Planning Application Ref: M/80/19/PL

Location: Former Poultry Farm, Land West of Yapton Road, Middleton on Sea, PO22 6DY

Description of works: Demolition of the existing structures & redevelopment to provide a new 66-bedroom care home (Use Class C2) arranged over two storeys together with associated access, car and cycle parking, structural landscaping and amenity space provision

Comments on Application:

Drawing no: PJC/5256/19/B Rev: - Sheet number: 4 of 4

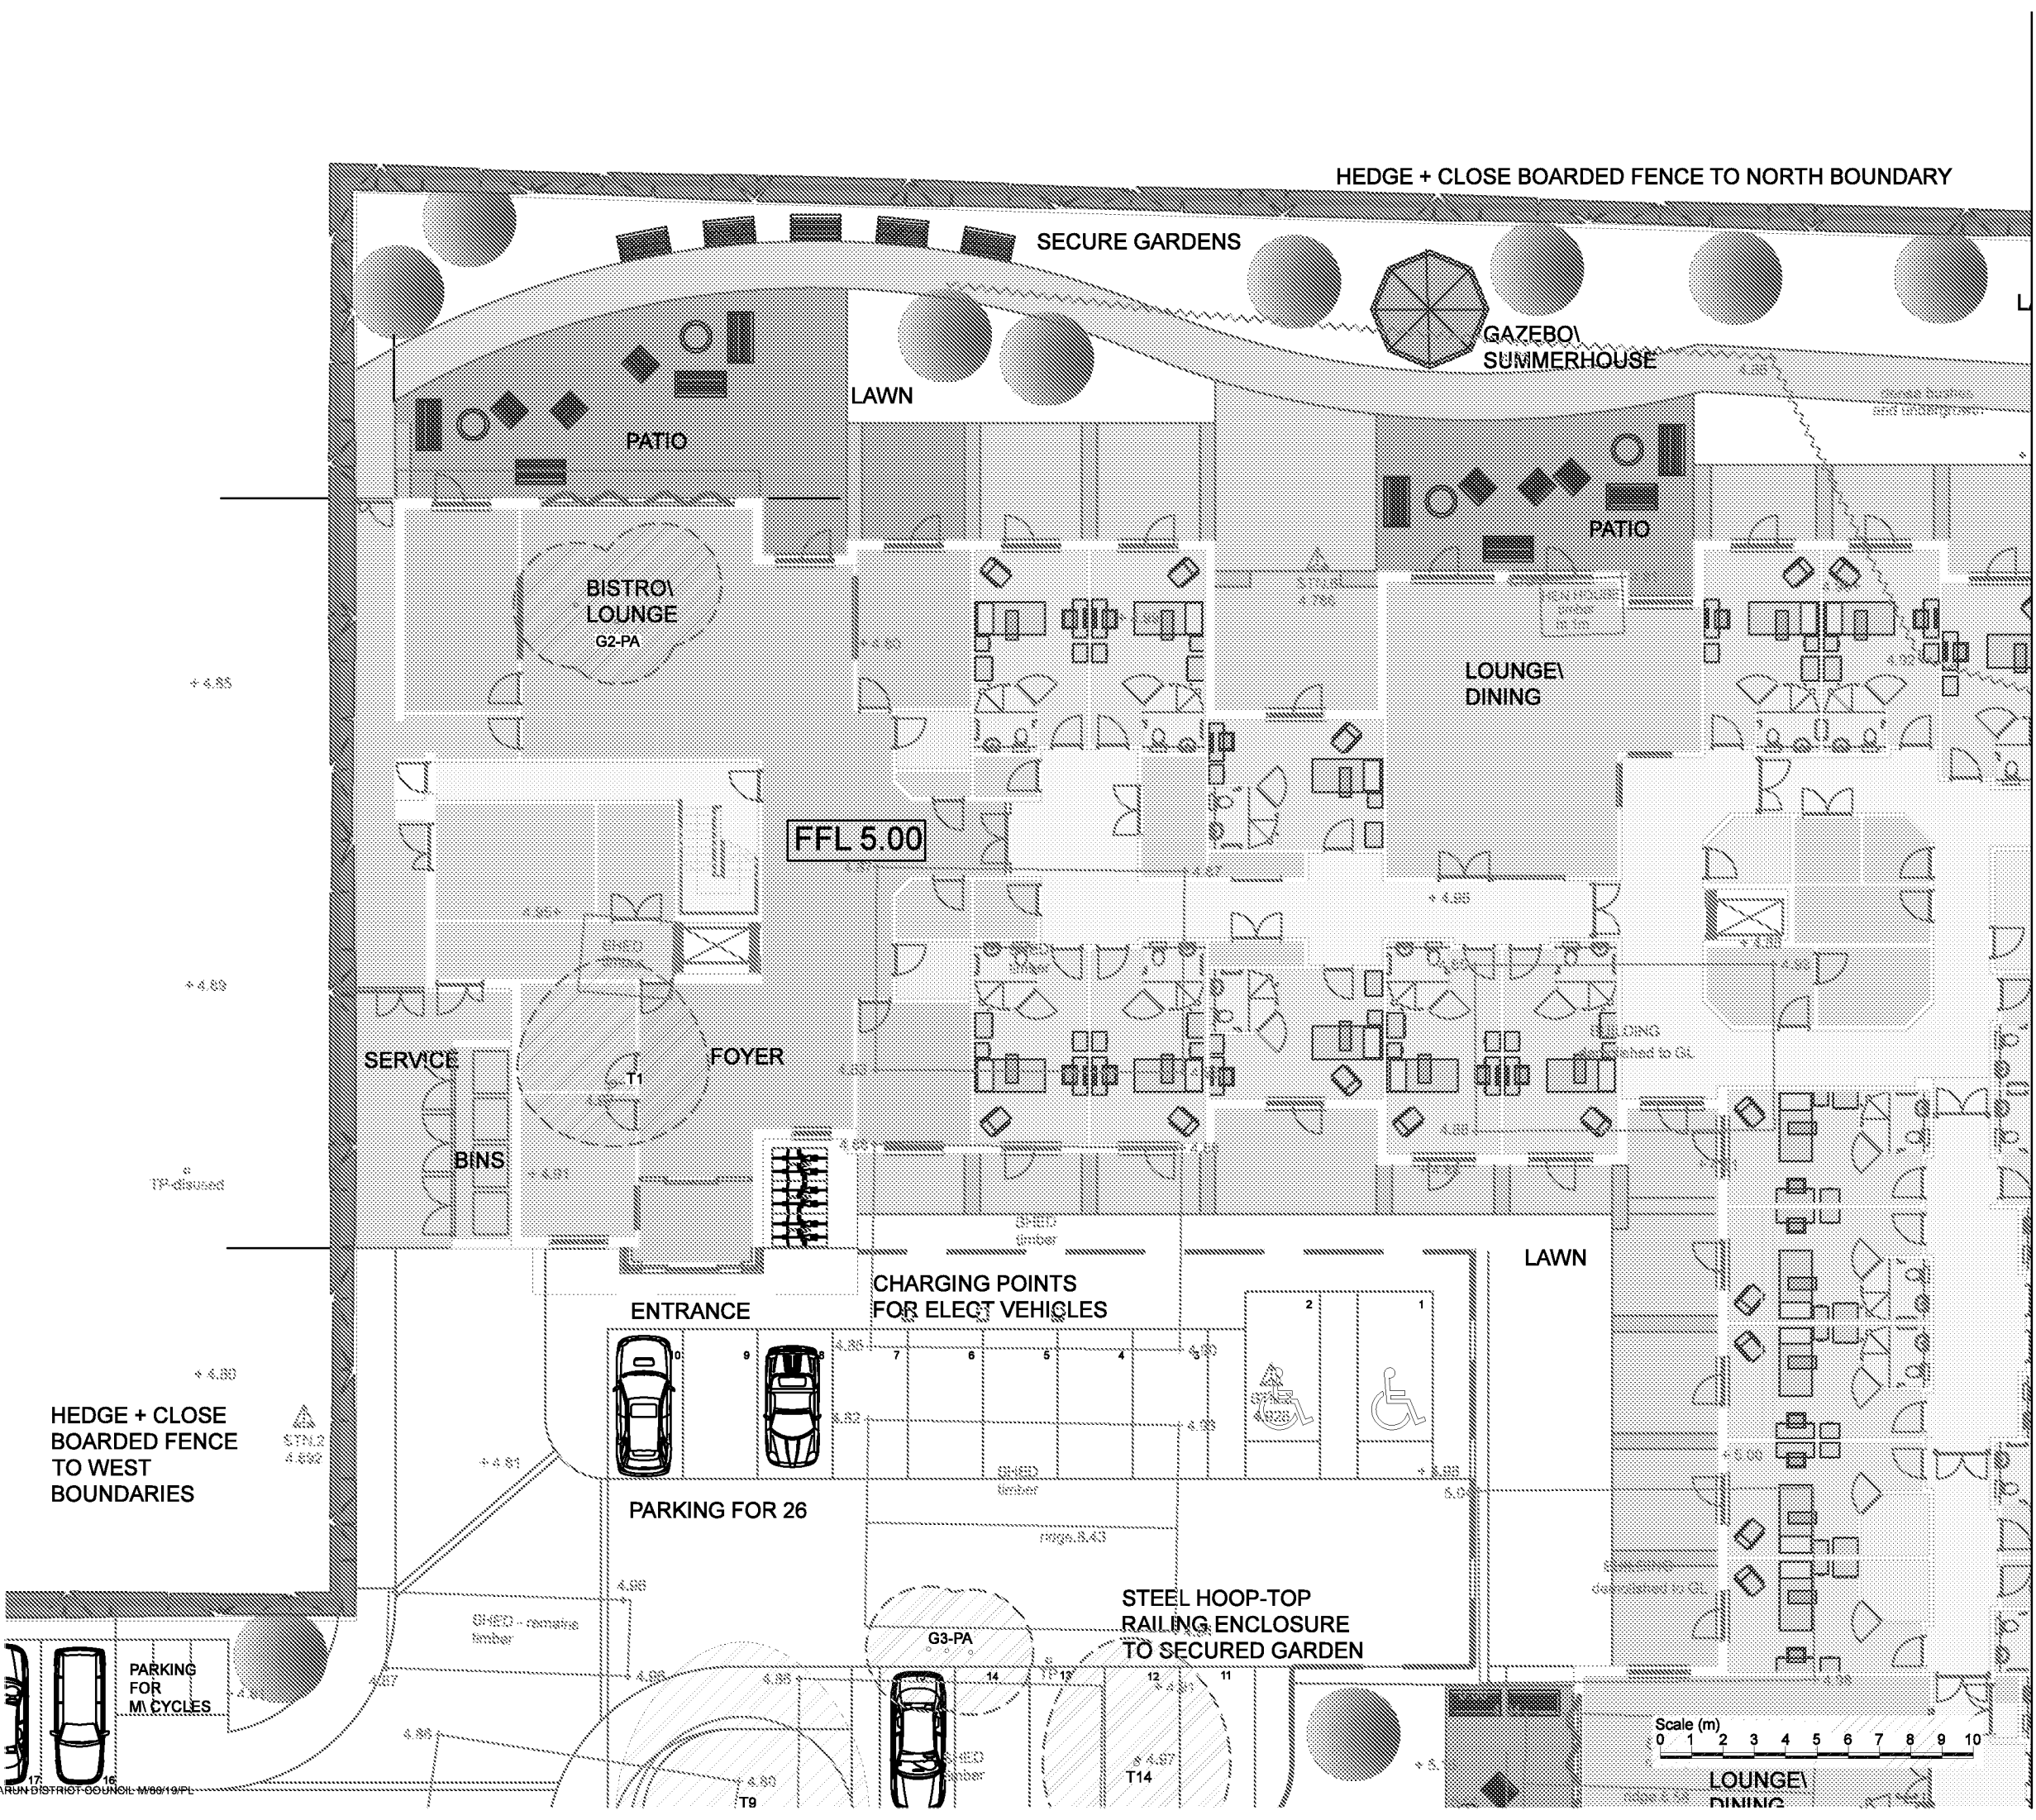
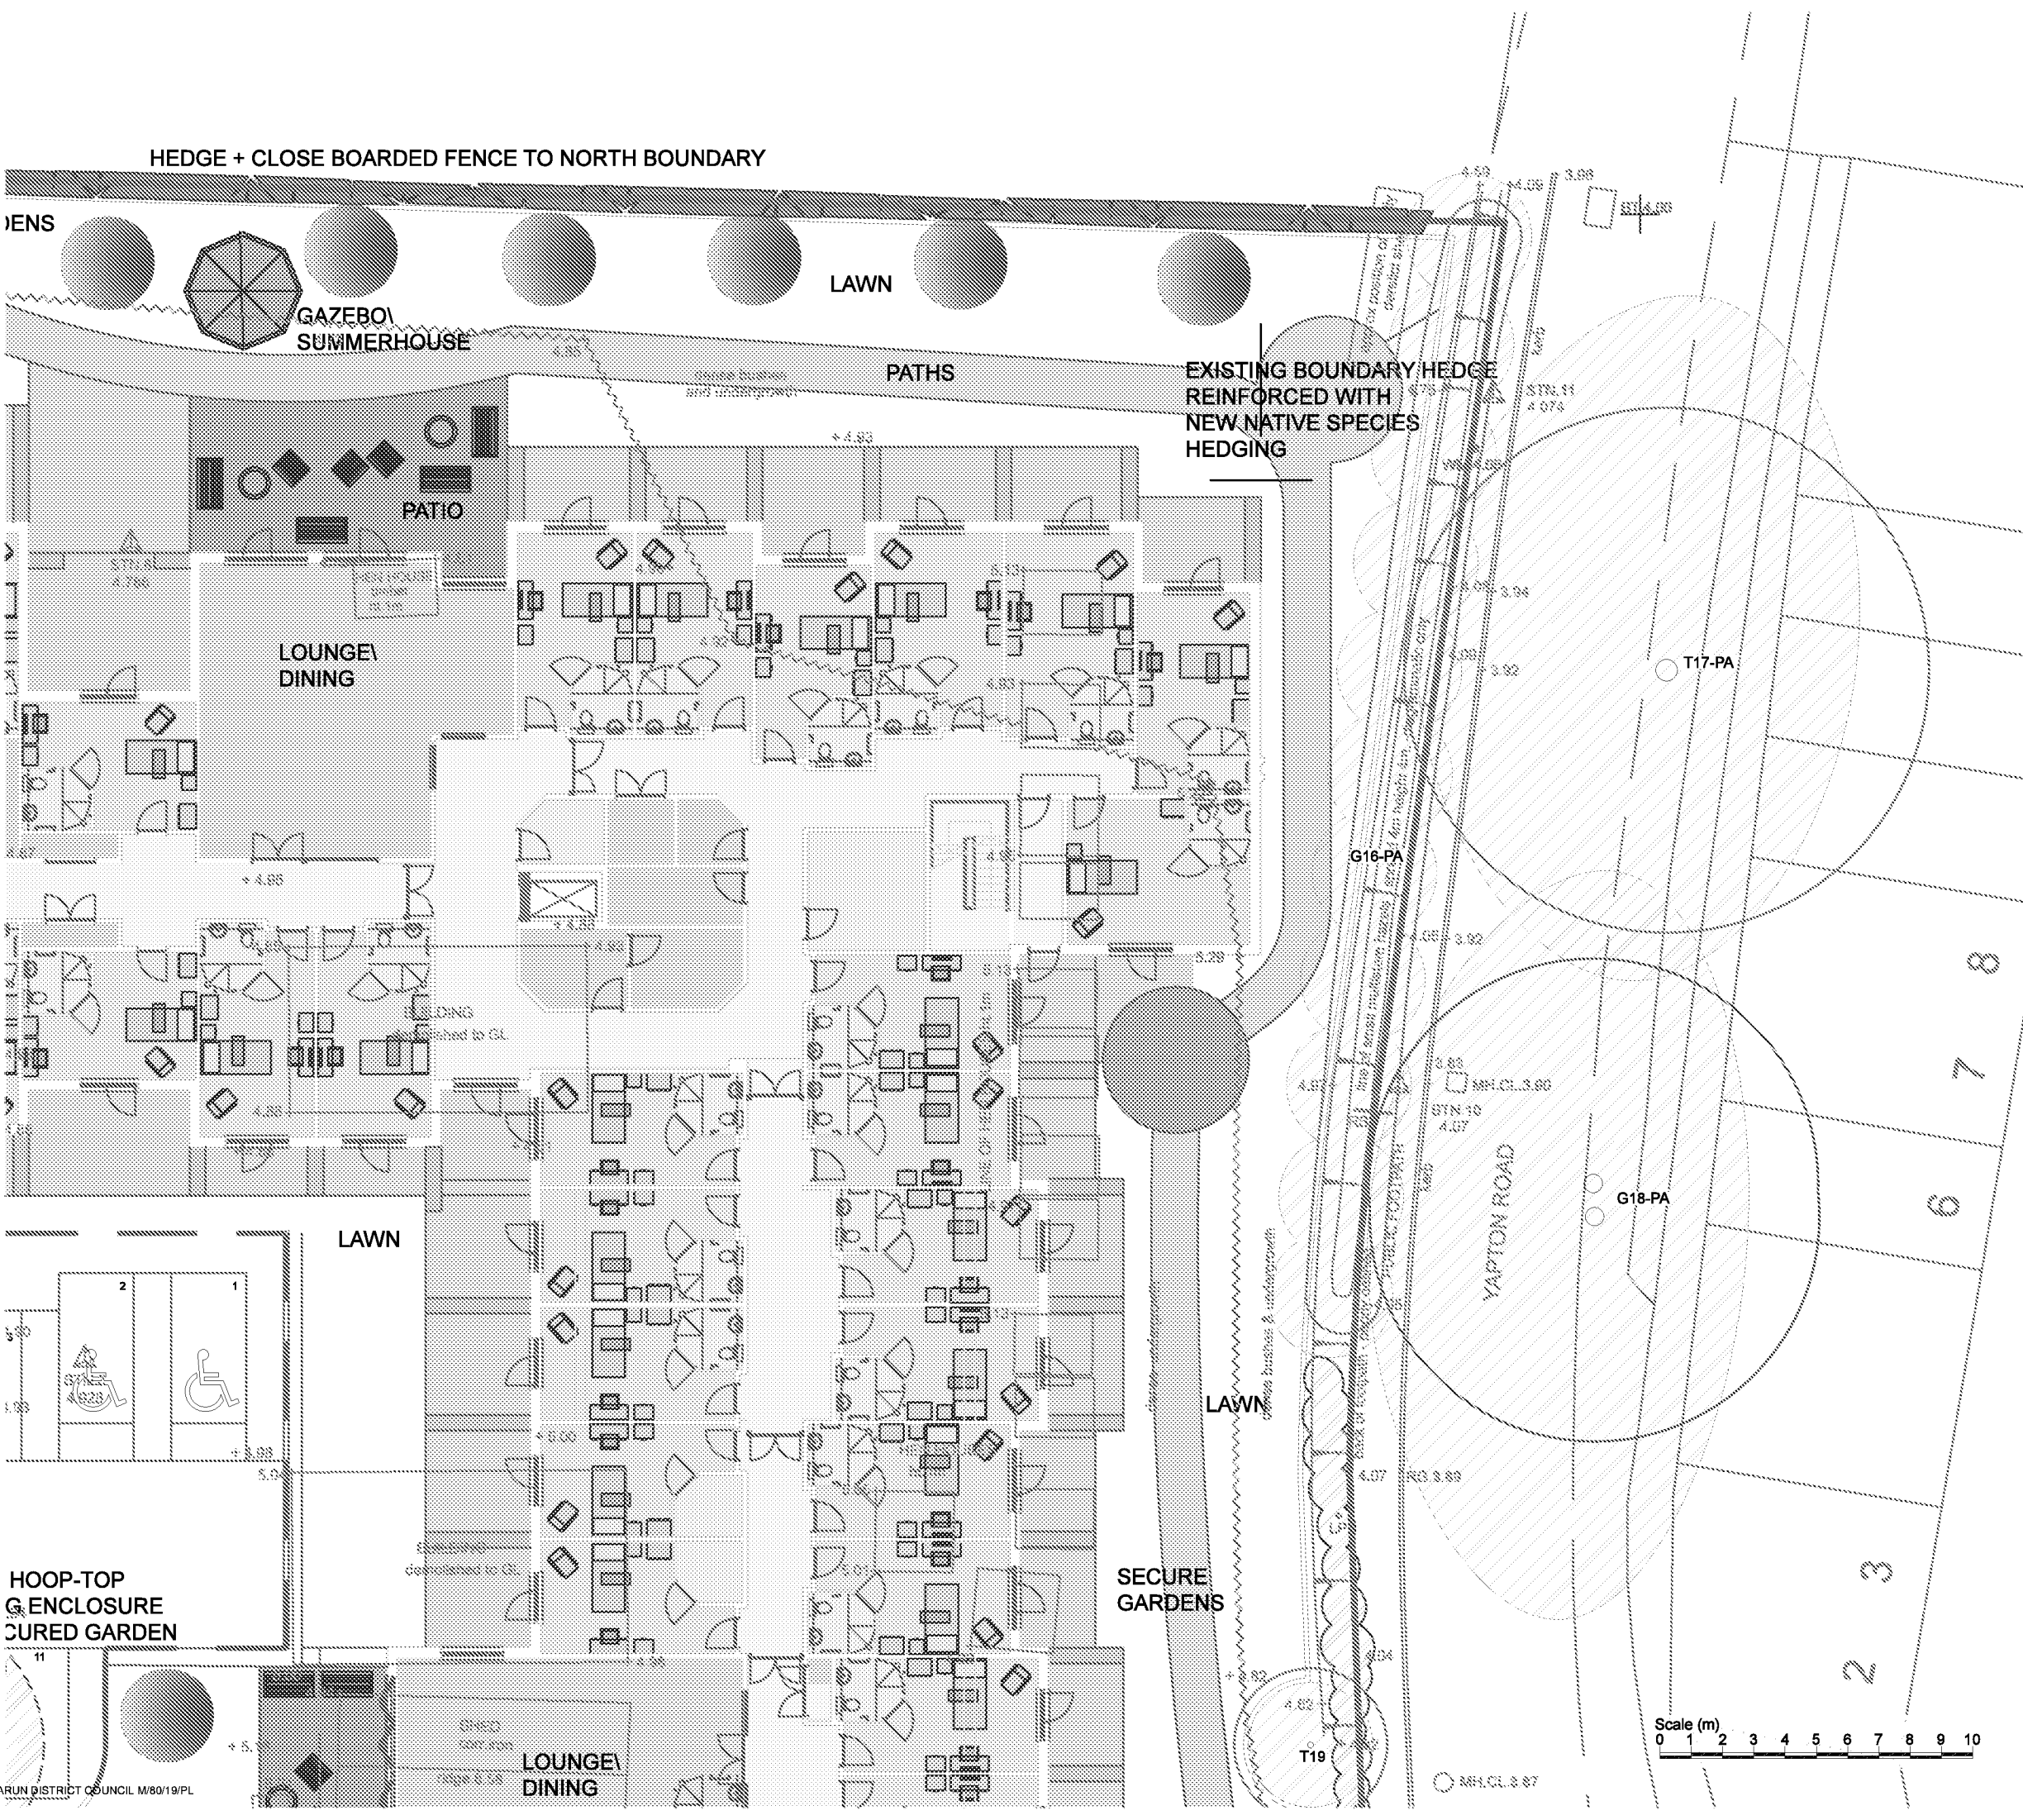
- Complex engineering solutions are proposed around the main site access to achieve adequate protection of retained trees either side and enhance the culvert/drainage infrastructure beneath. I support the principle of this element of the scheme although we have yet to see adequate detail in the form of an *engineers construction method*, which will need to be submitted for our consideration and approval.

- If considered absolutely necessary from an engineering perspective (to be determined on receipt and approval of an *engineers construction method*), I would support the removal of ash tree T04 to facilitate a more standard form of construction across the culvert and on approach to the main site access), so long as parking bays 28 & 29 were left as unmade ground and there was replacement planting of a semi-mature pedunculate oak (minimum 30cm girth, containerised stock, UK homegrown) in undisturbed open ground immediately to the north of T04 and made subject of a new Tree Preservation Order. Furthermore, the no-dig footway proposed within nominal RPA of T10 field maple would have to remain part of the overall scheme.
